PORTLAND MAINE

April 5, 2010

RE: 135 Warren Ave.
CBL: 295 C003001

This letter serves as a follow up to my inspection on April 1, 2010. The house violations are pretty well resolved, there are a few minor things, some as a result of corrections, and the setbacks to the storage containers were not clearly attainable:

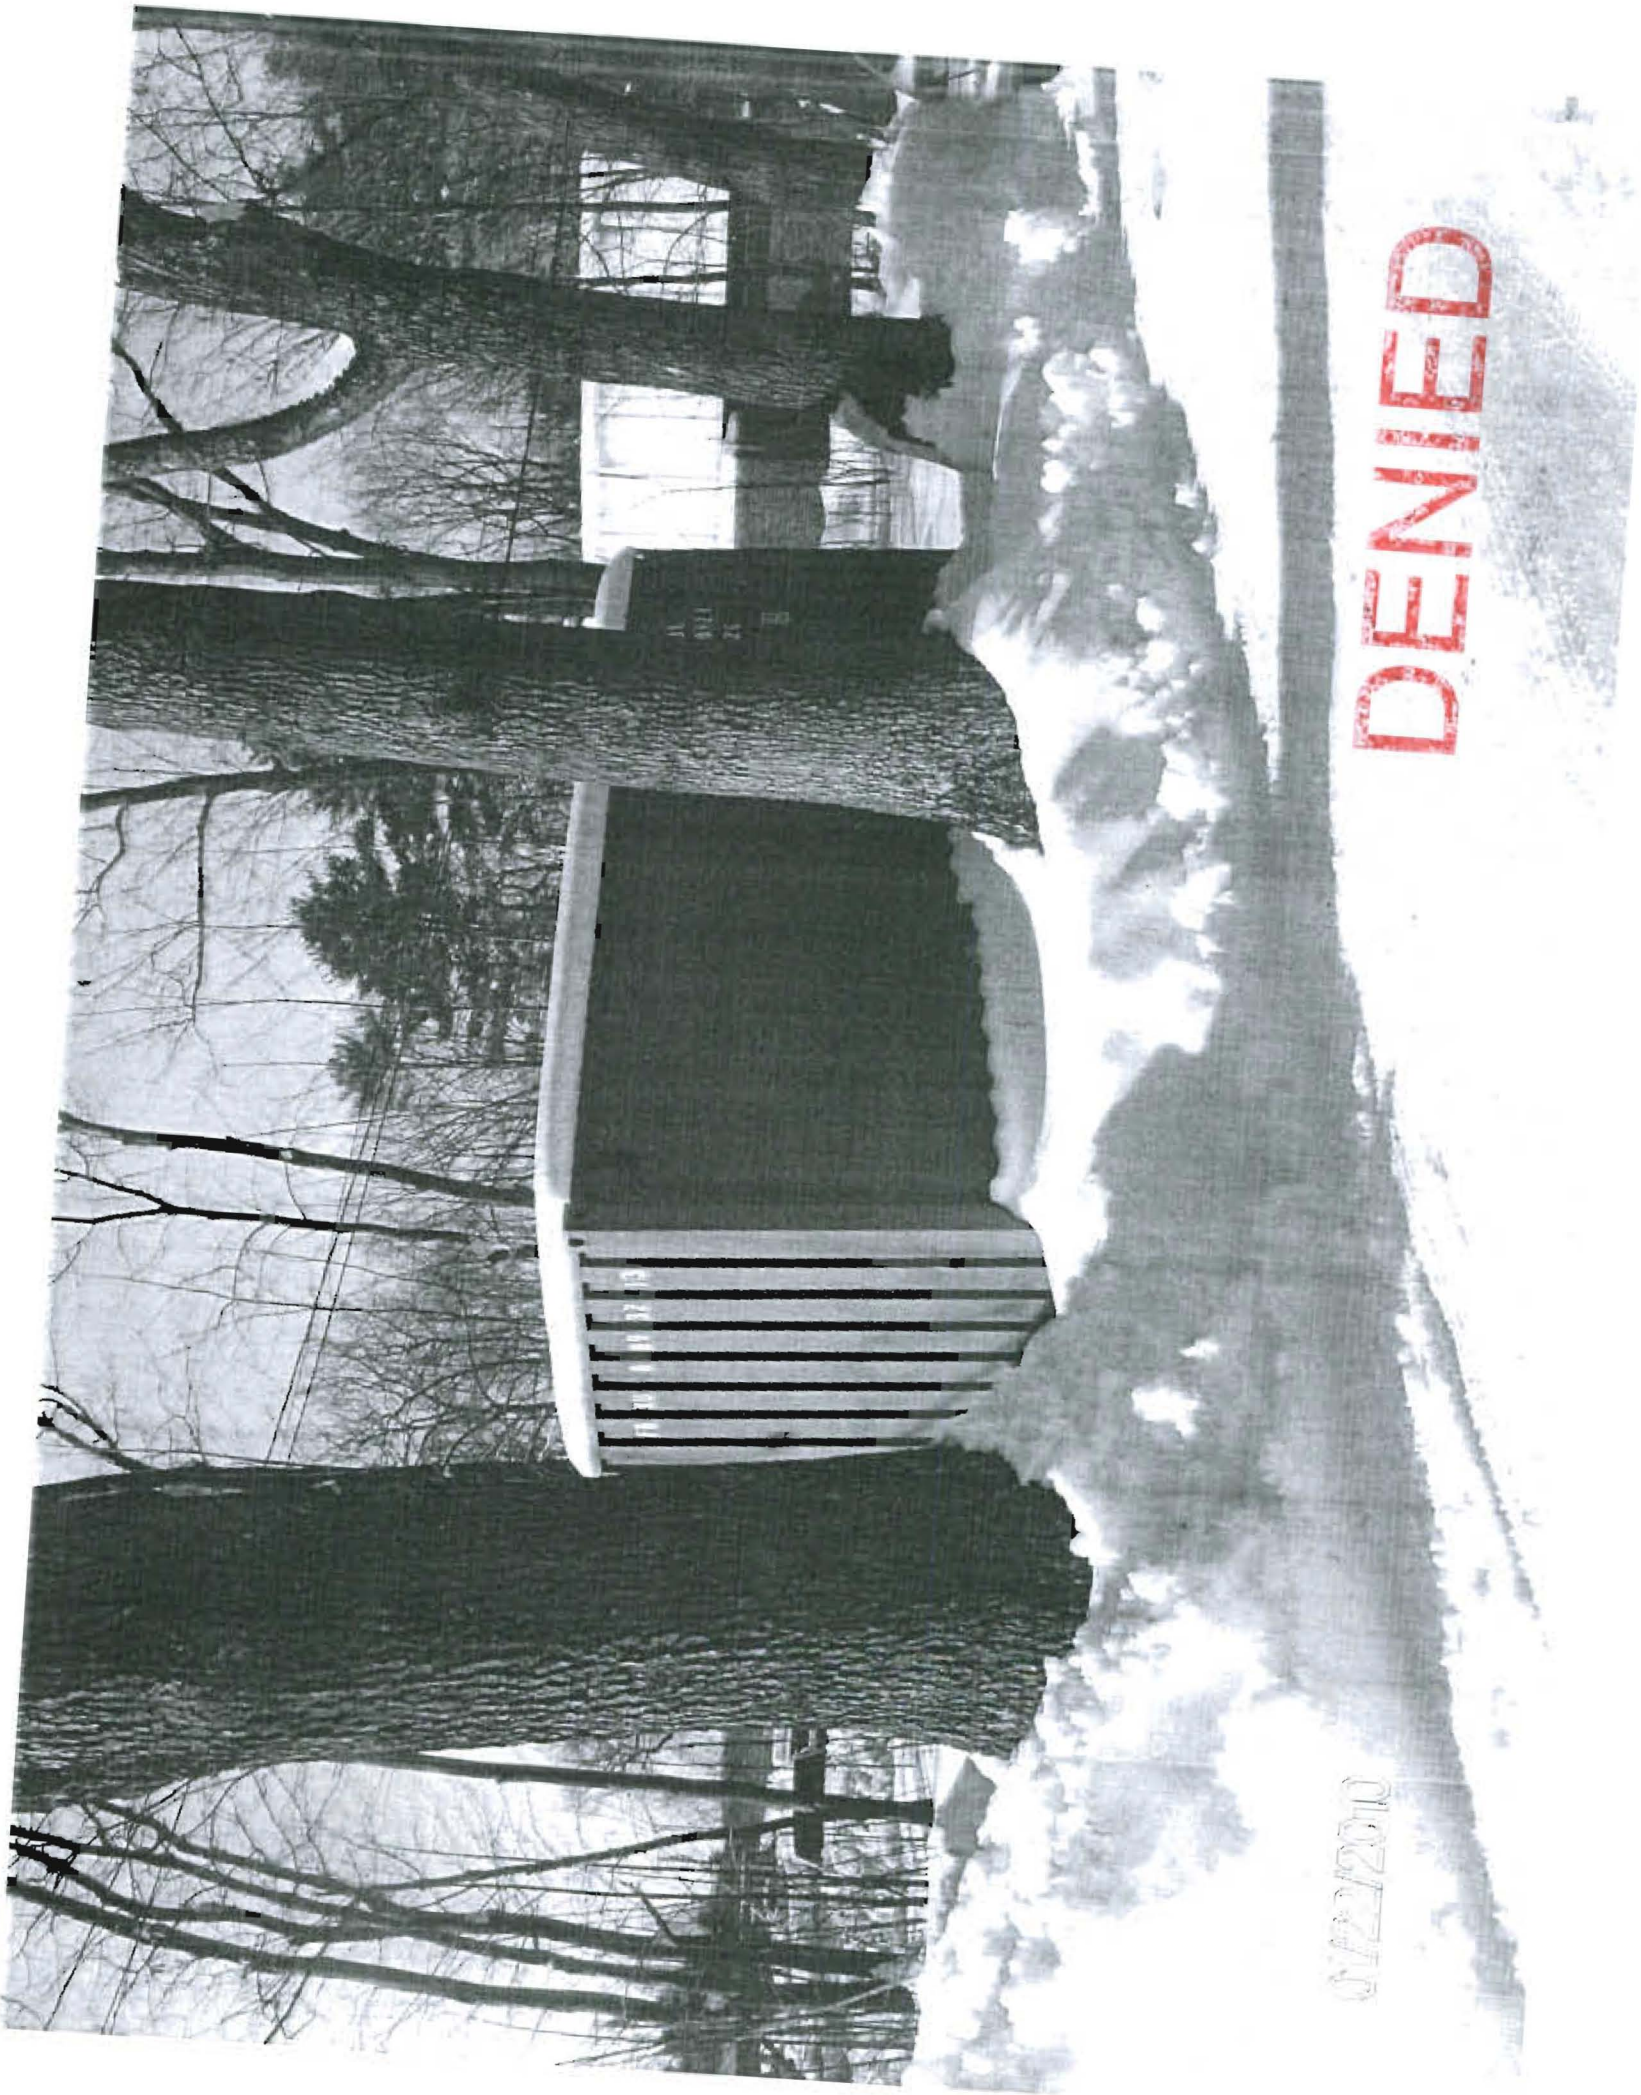
1. The boiler off switch needs to be moved to the bulkhead entrance since the interior stairs to the basement were removed and blocked off. This work shall be done by a licensed electrician.
2. Electrical outlet covers needed in basement and extension cords discontinued
3. A graspable handrail is needed on the exterior steps
4. Finished flooring and trim is needed at the pass thru on the 1st floor to block smoke passage from basement storage area
5. Charlie Tanner needs to clean up the site of some tires and a large sign post from a previous location.
6. There were stakes laid out to measure the setbacks, but not in a straight line and I have no idea how this line was established.
